**City of Portland, Maine - Building or Use Permit Application**

Location of Construction: 134 NOYES ST	Owner Name: BURROWS DONALD C & PATRI	Owner Address: 134 NOYES ST
Business Name:	Contractor Name: Scott Forbes 772-3380	Contractor Address: 188 Capisic Street Portland, ME 04102-3380
Lessee/Buyer's Name:	Phone:	Permit Type: Additions - Dwellings

Past Use: Single Family Home	Proposed Use: Single Family Home / add 1 story approx. 18' x 20' attached garage	Permit Fee: \$201.00	Cost of Work: \$20,000.00	CEO District: 3
---------------------------------	---	-------------------------	------------------------------	--------------------

**Dept:** Zoning      **Status:** Approved with Conditions      **Reviewer:** Tammy Munson      **Approval Date:** 09/14/2005

STAIR DETAIL

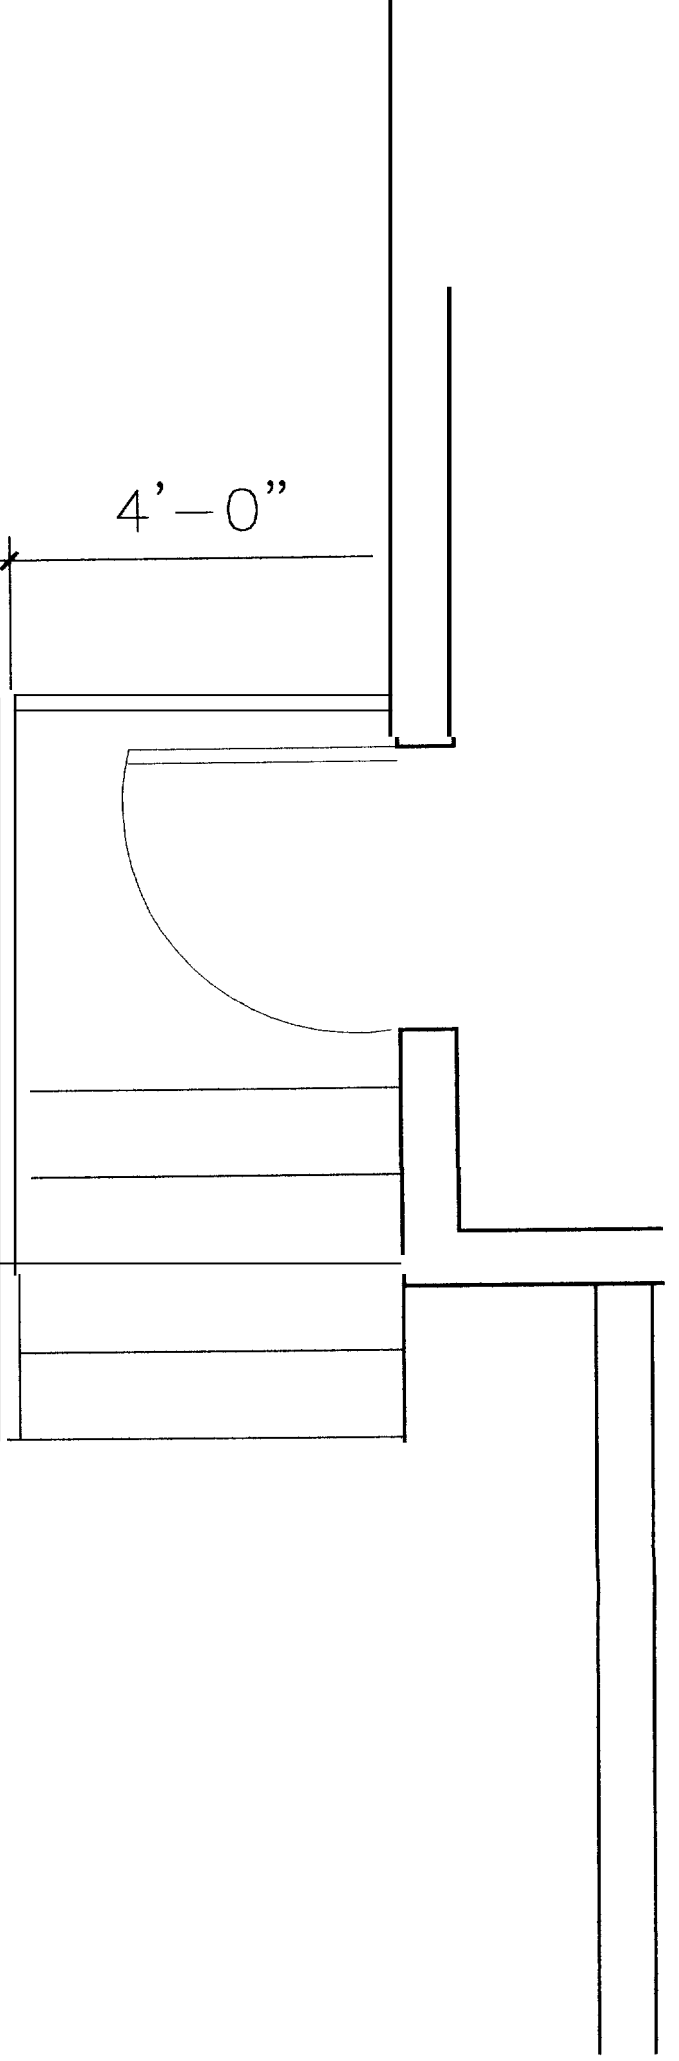
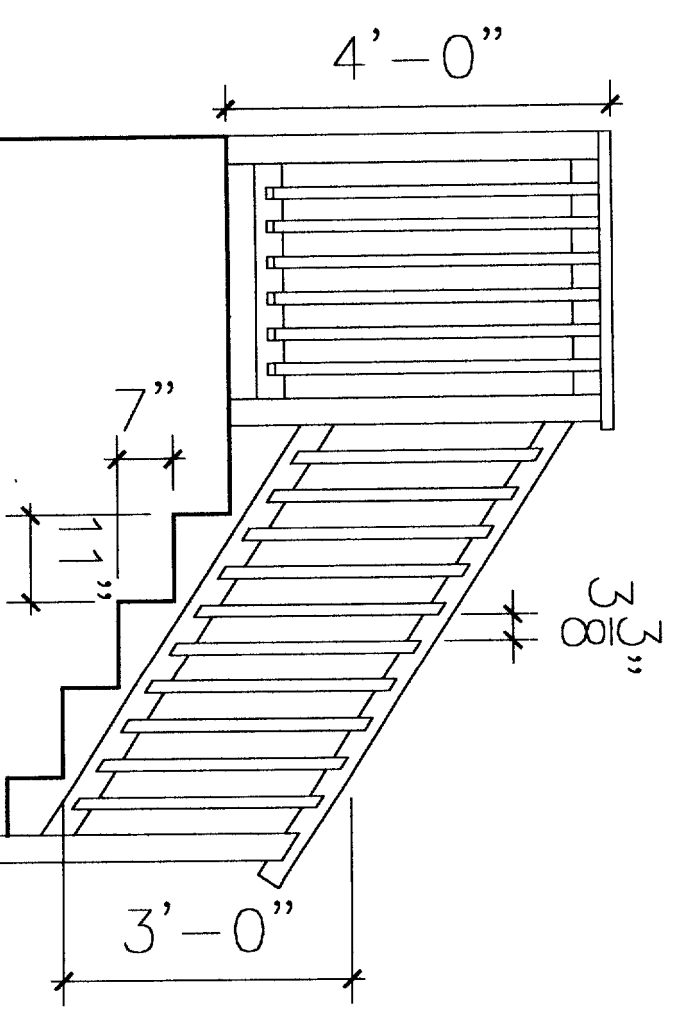
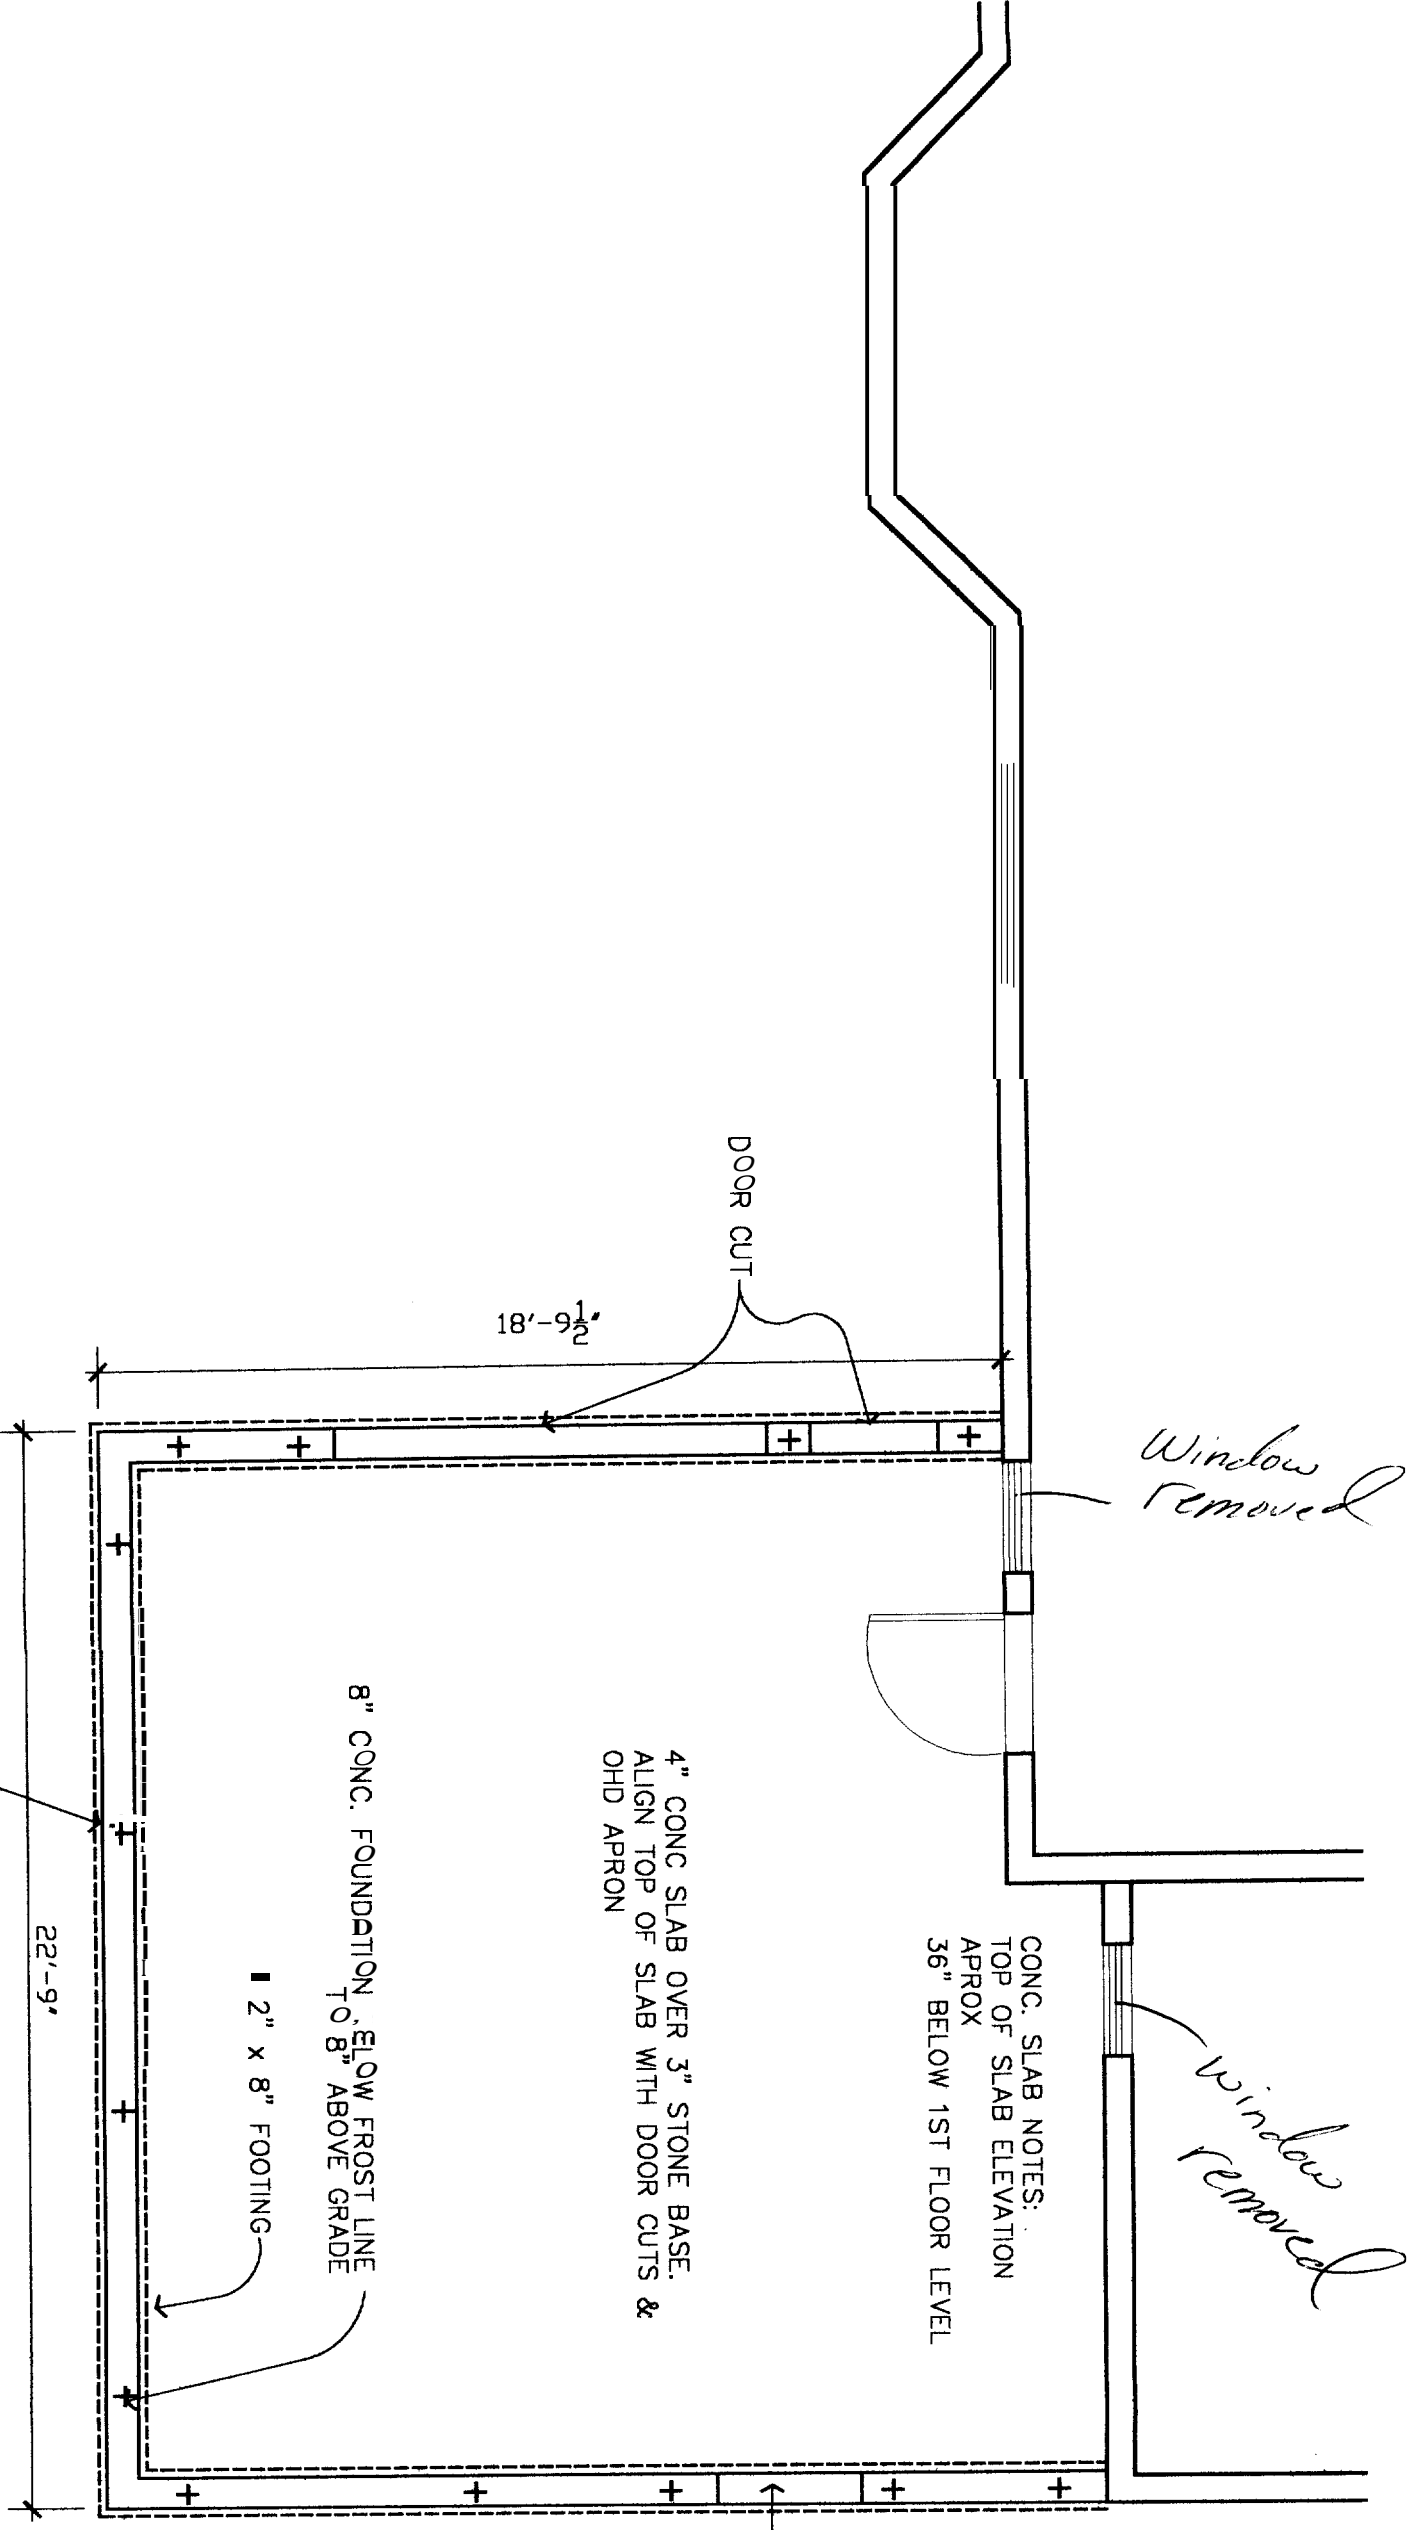
8/11/05-tmm: spoke w/builder - need guardrail detail, need surveyor to set foundation, need to remove existing windows in common wall between house and garage.

NOYES STREET  
(PAVED PUBLIC 60' WIDE)

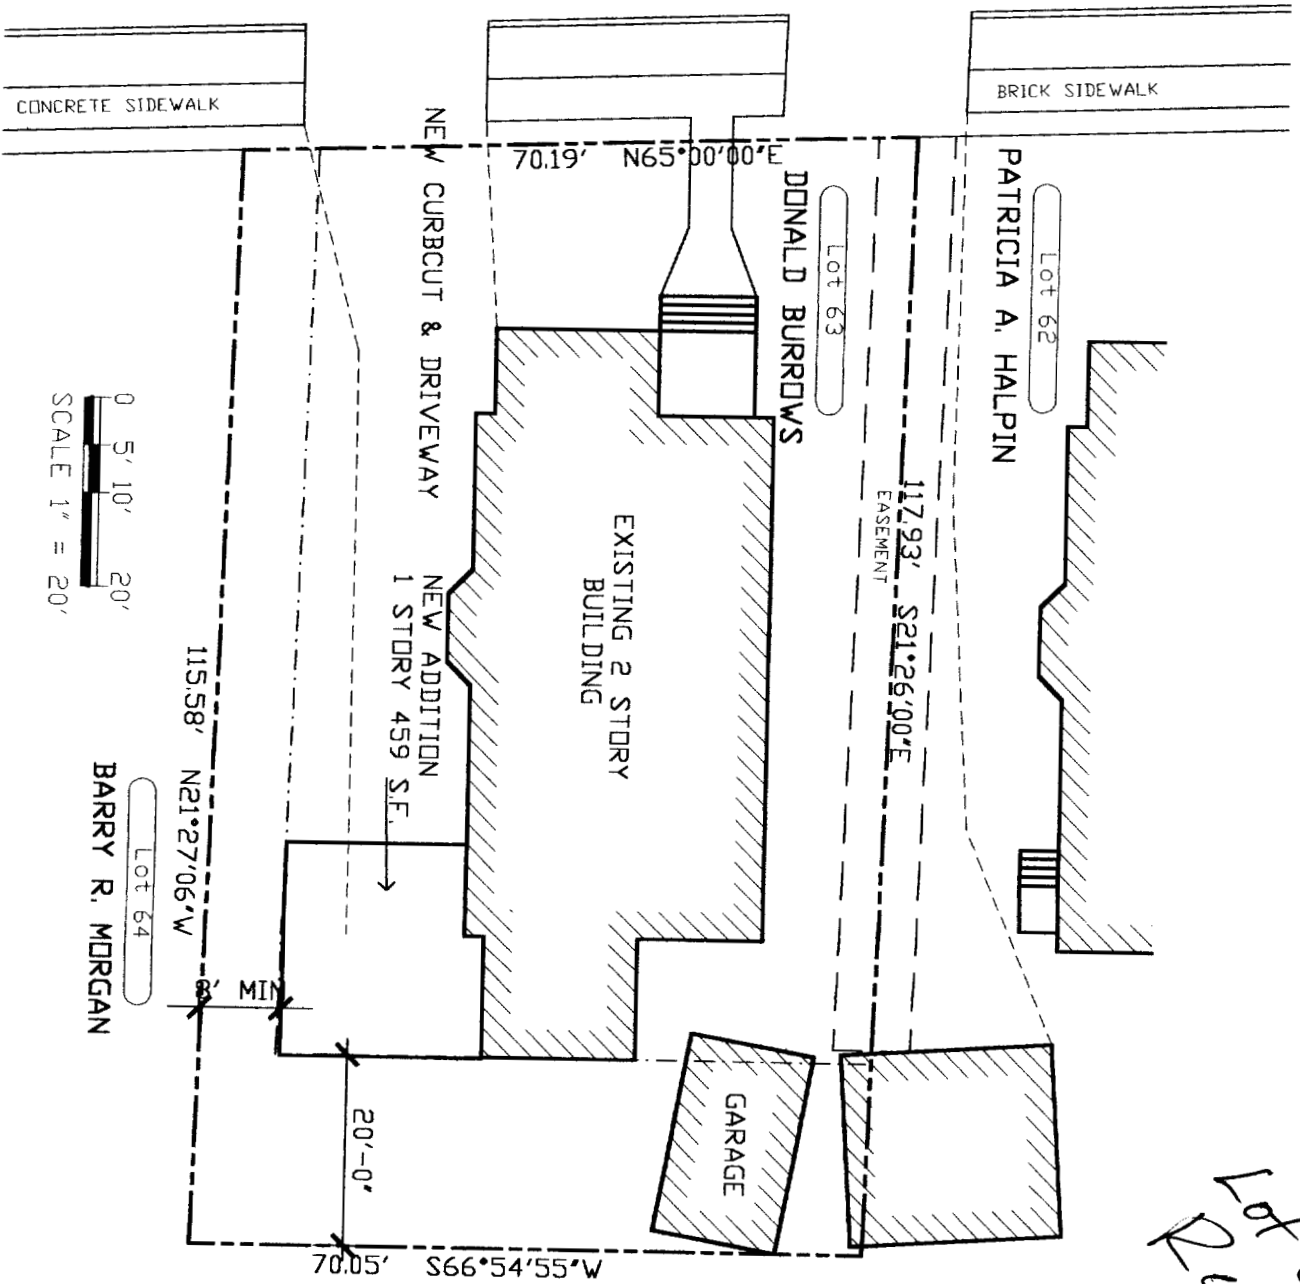
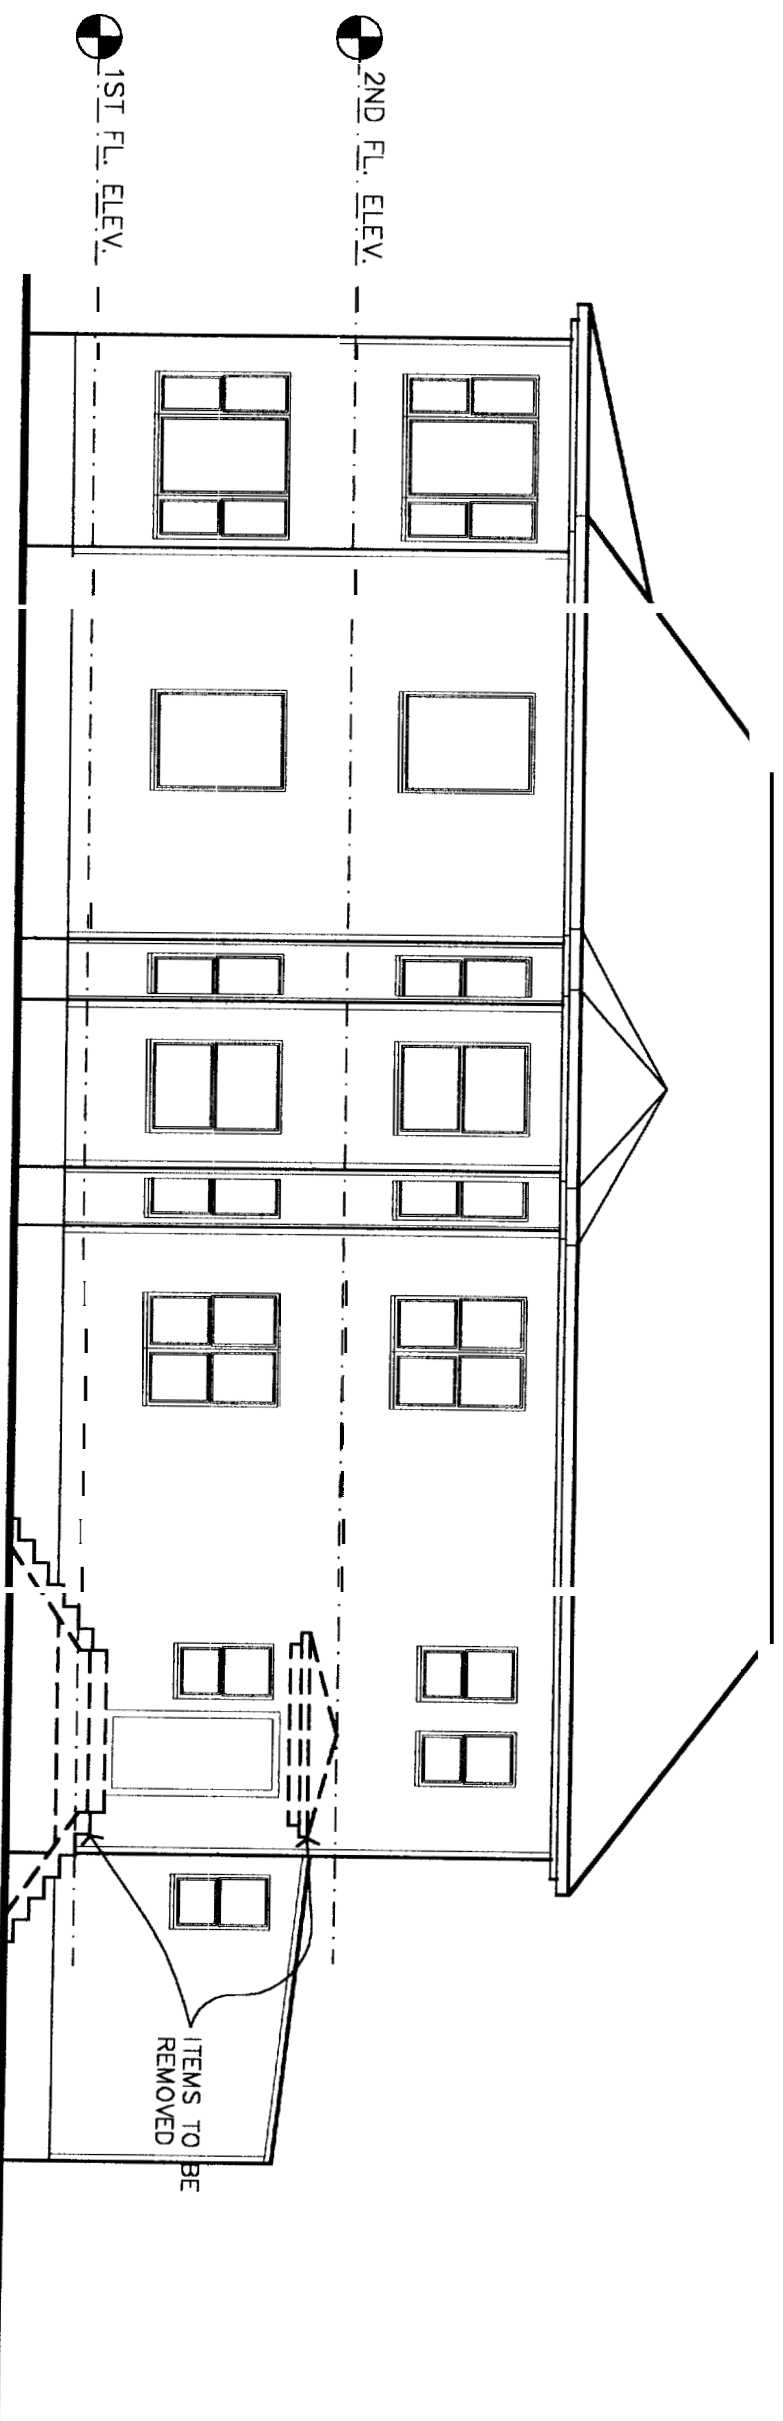
- 1) As discussed during the review process, the property must be clearly identified prior to pouring concrete and compliance with the required setbacks must be established. Due to the proximity of the setbacks of the proposed addition, it may be required to be located by a surveyor.
